Current Zoning: MUDD-O (Mixed Use Development District, Optional)
Proposed Zoning: MUDD-O SPA (Mixed Use Development District, Optional, Site Plan Amendment)

Approximately 10.6 acres bound by the south side of Abbey Place, east side of Park Road, west side of Hedgemore Drive, and north side of Mockingbird Lane.

The petition proposes to increase the number of residential units from 450 units to 550 units.

SHEET NUMBER  
**RZ-1**

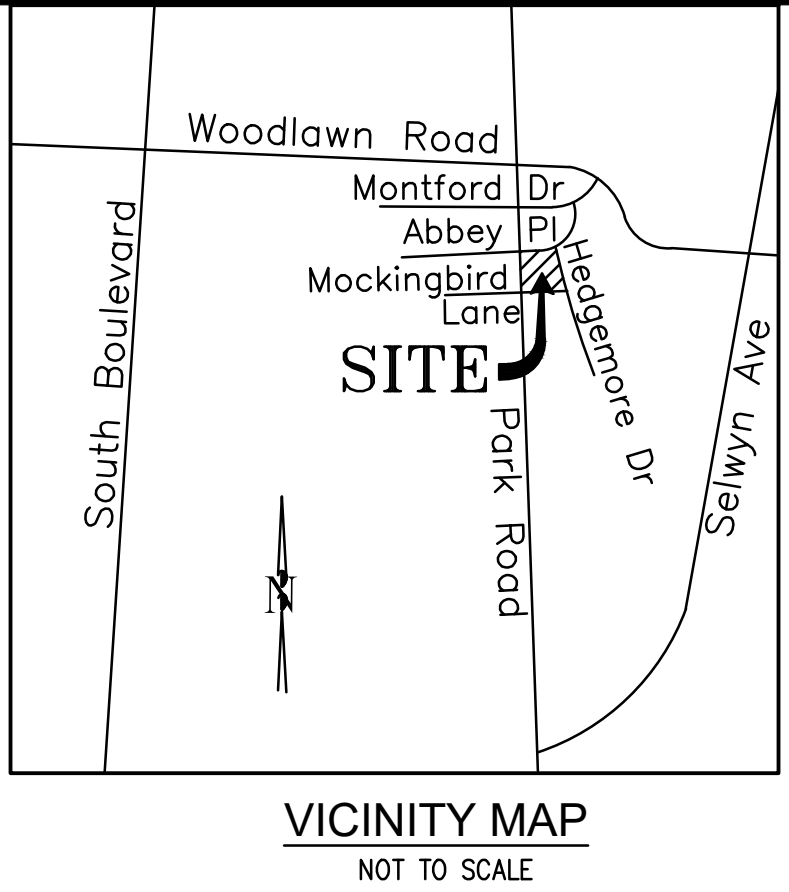
1. ~~Site plan needs to show dimension of future back of curb from centerline.~~ [Addressed](#)

2. ~~Tree survey required. Missing street trees along Hedgemore Drive, Mockingbird Lane, and Abbey Place.~~ [Addressed](#)
